SUBJECT: SSD-100271209 – REQUEST FOR COMMENT

Property: Lot 2 DP 1293342, Roy Watts Road, GLENFIELD

Development: Landcom's Glenfield affordable housing project

Ground Floor Overall Plan

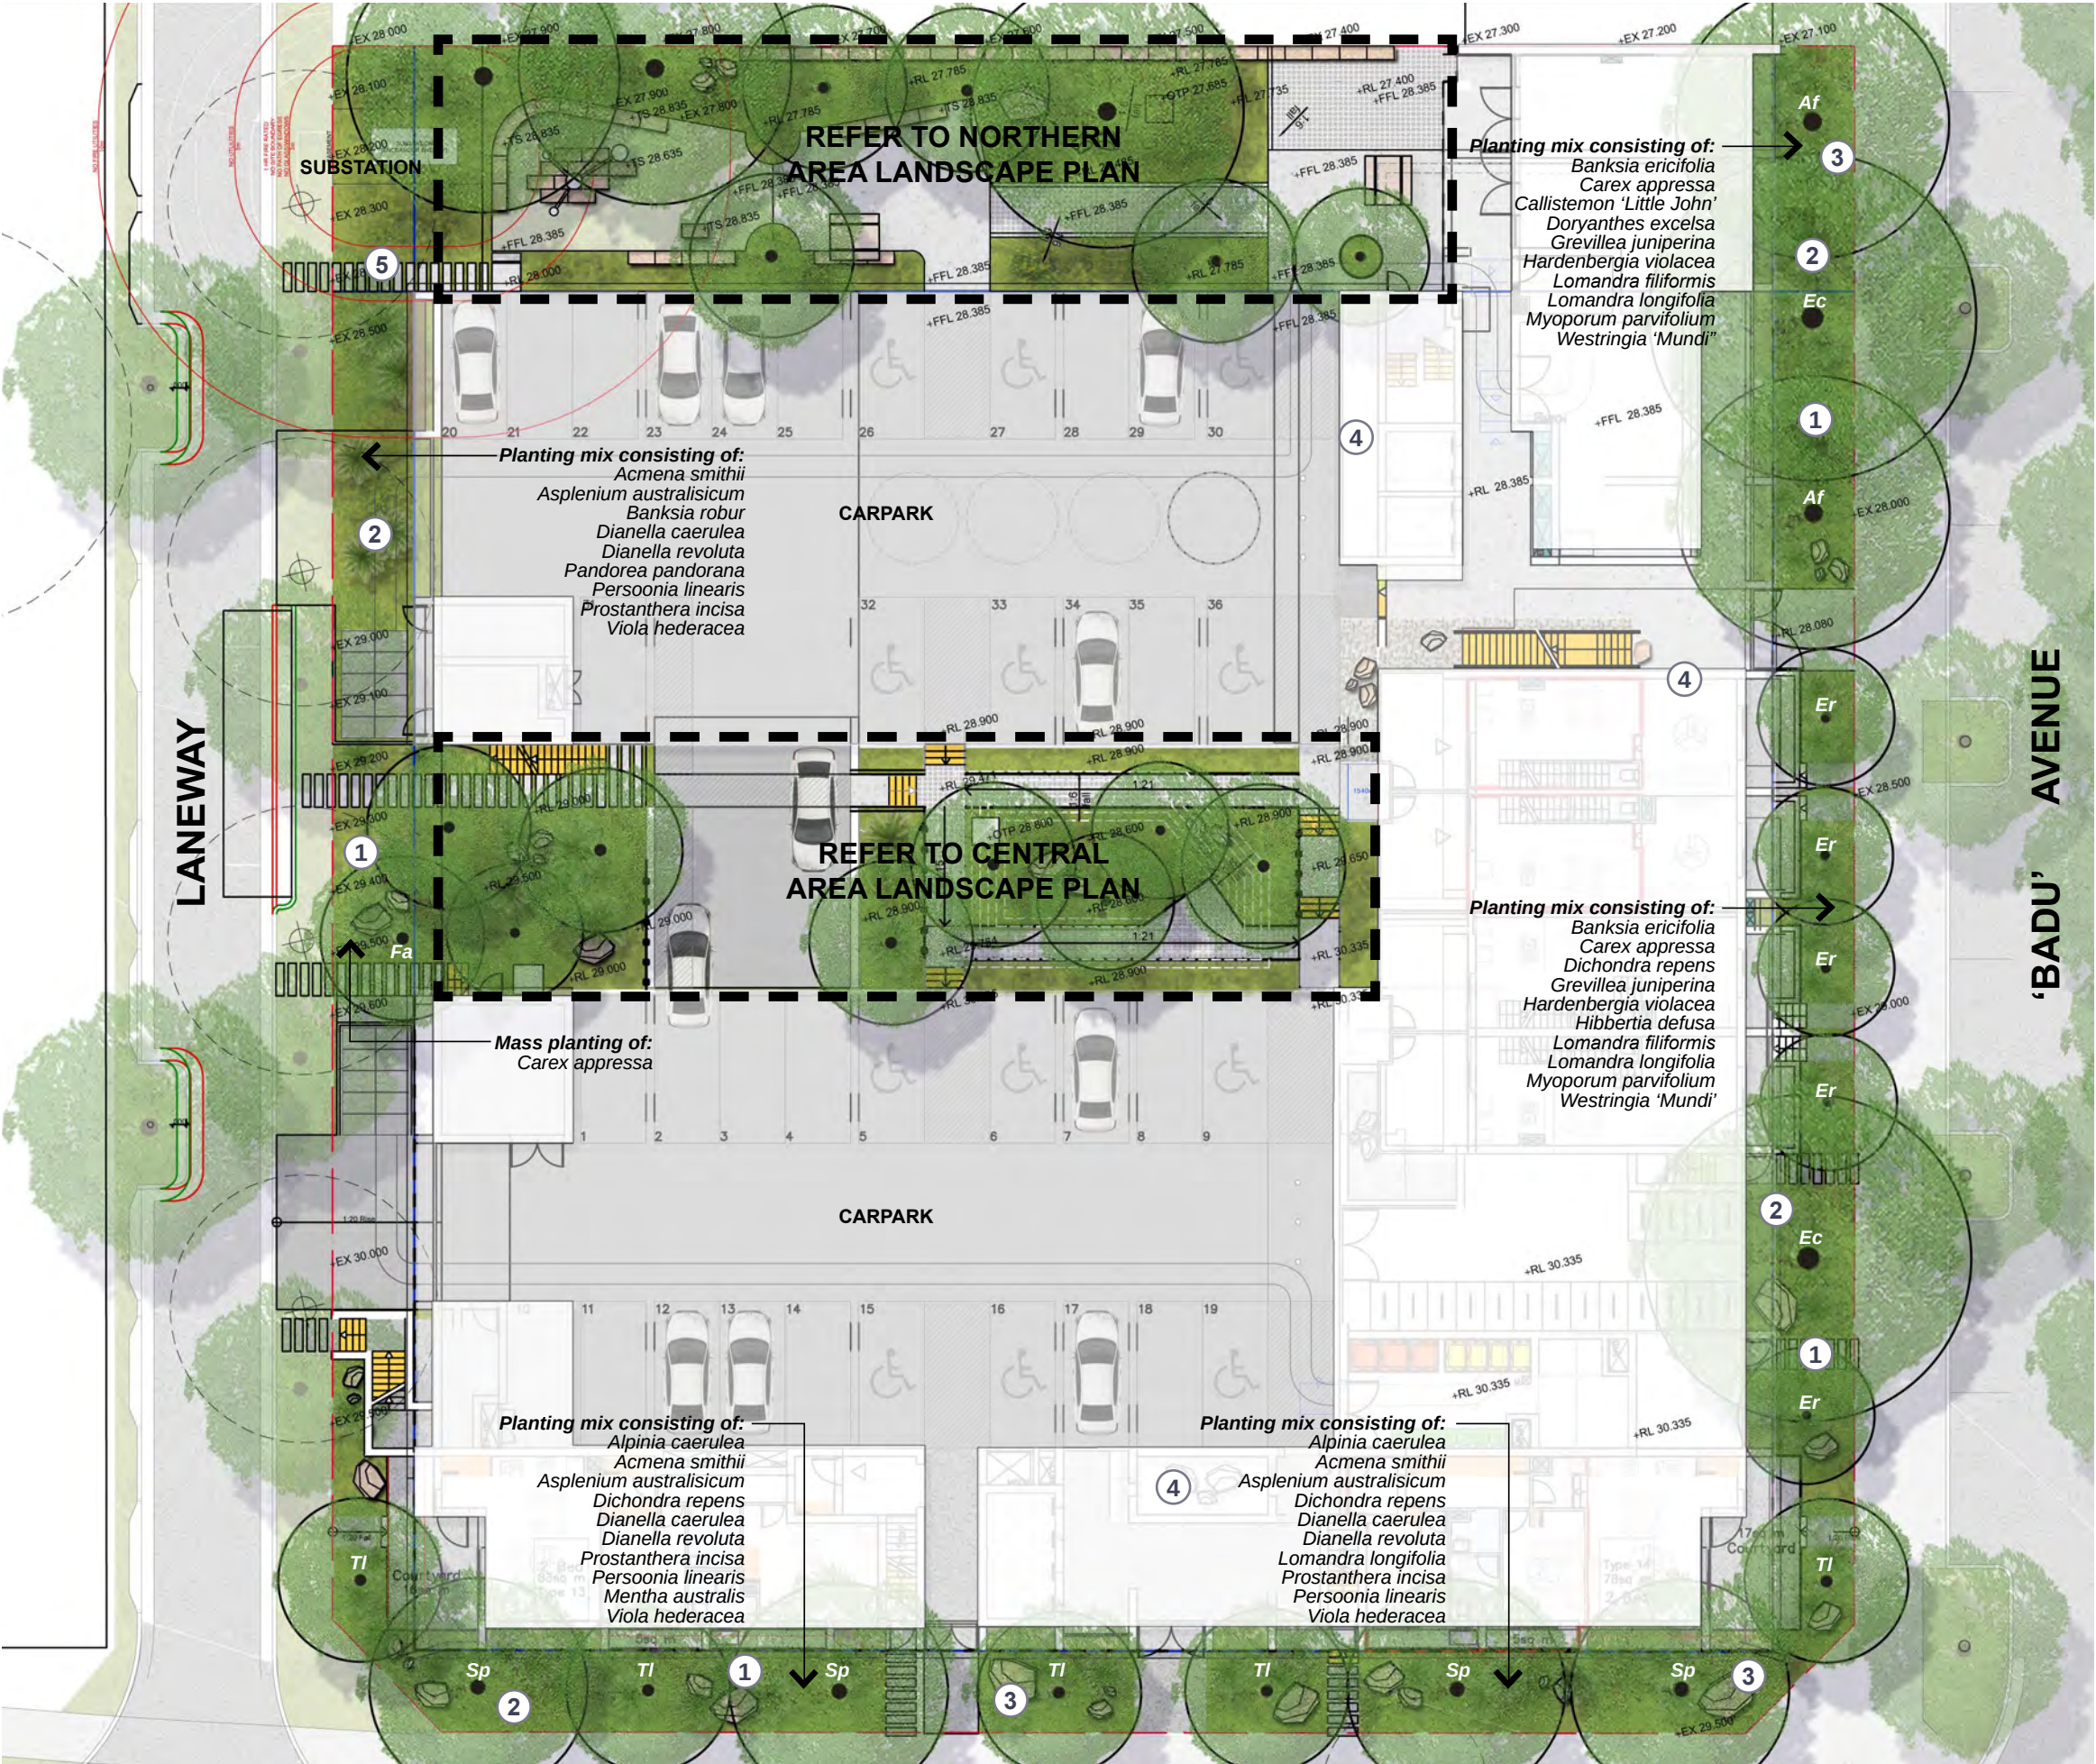
However, sufficient information has not been submitted to demonstrate that stormwater from the proposed development can be discharged by gravity to the future drainage system in Water Avenue. Council suggests the provision of a computerised drainage model to ensure that water can reach the street by gravity.

- i. No information has been provided regarding the basement drainage disposal method and its connection to the drainage system in Water Avenue.

- ii. As the driveway ramp to the basement carpark is proposed through a large open area between the northern and southern carparks, a significant volume of stormwater is likely to enter the basement during major storm events, which is not acceptable.
- iii. The basement ramp is not covered, contrary to Cl 4.13.8 of Council's Engineering Design for Development guide.
- iv. No information has been provided to demonstrate that the basement entry level is at or above the 1% AEP flood level within the access road, to ensure the basement is protected from flooding.

- v. It has not been demonstrated how overland flow paths within the enclosed area surrounded by the north and south buildings will be managed.
- vi. Finished surface levels have not been provided to demonstrate the overall management of overland flow paths across the site during major storm events.
